# PAINT BRUSH HILLS METROPOLITAN DISTRICT SCENIC VIEW AT PAINT BRUSH HILLS POND MODIFICATIONS

MAY 2022

Update to include the entire EPC Construction notes. See document.

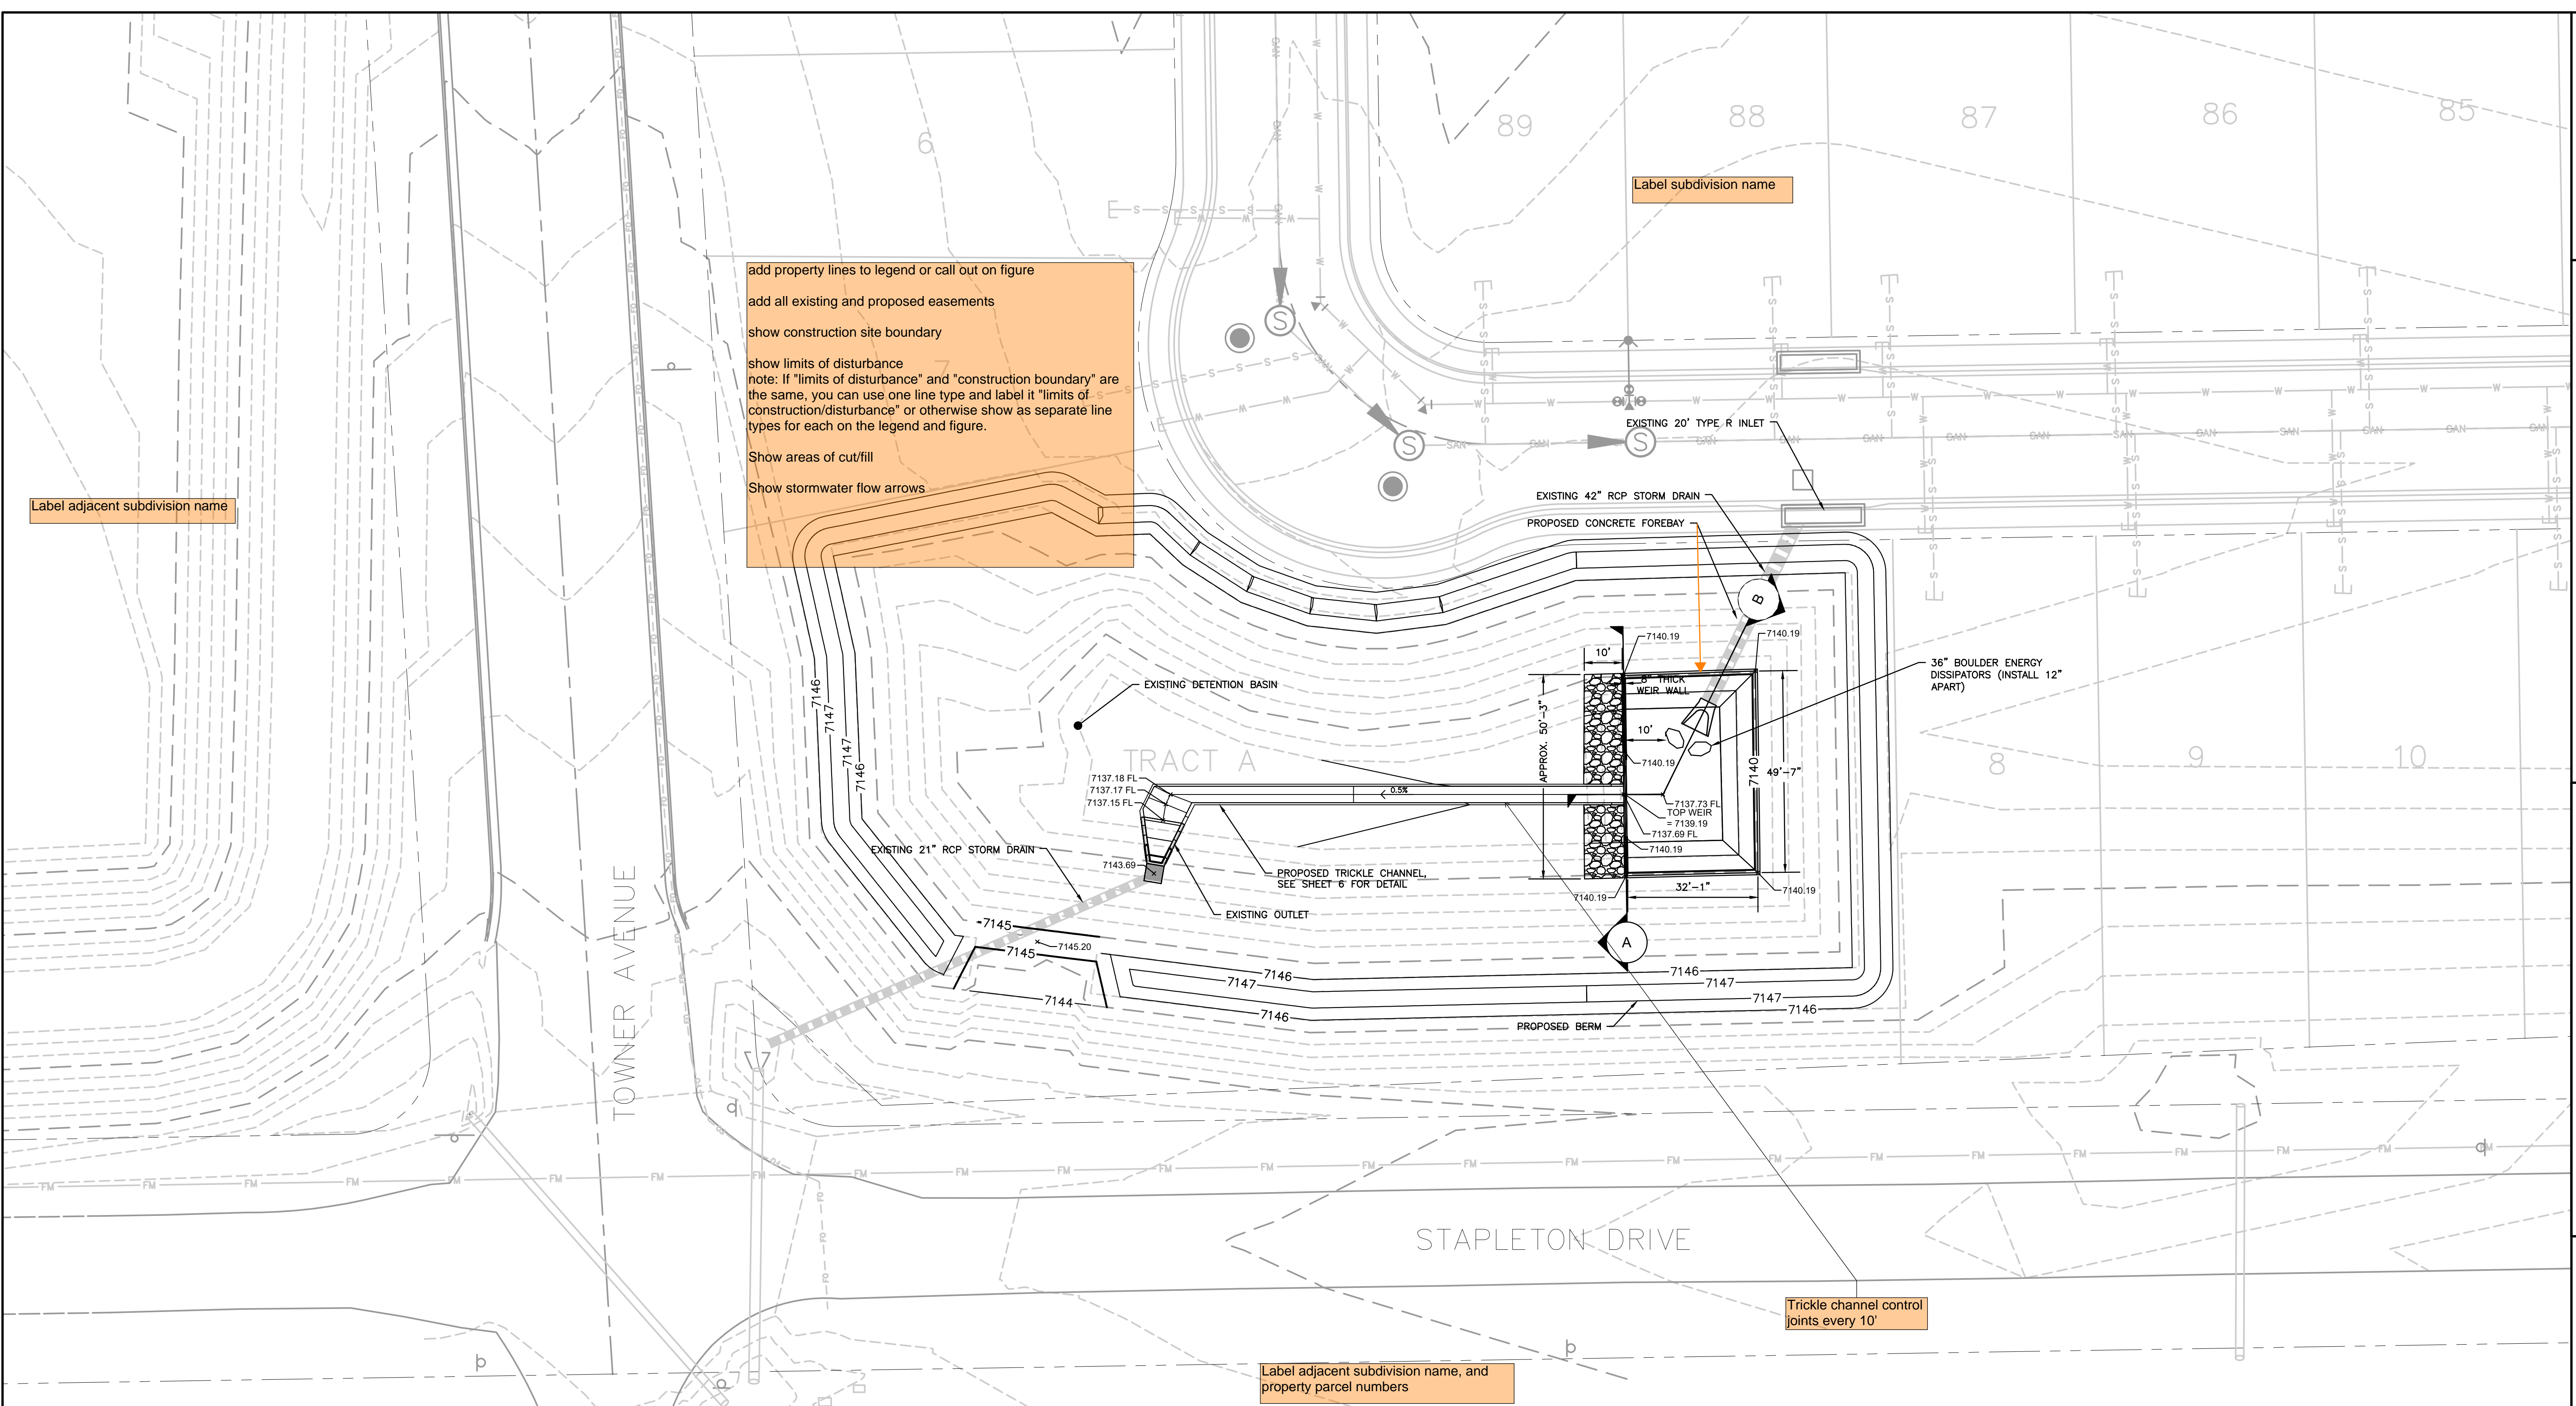
Update to include the entire EPC Construction notes. See document.
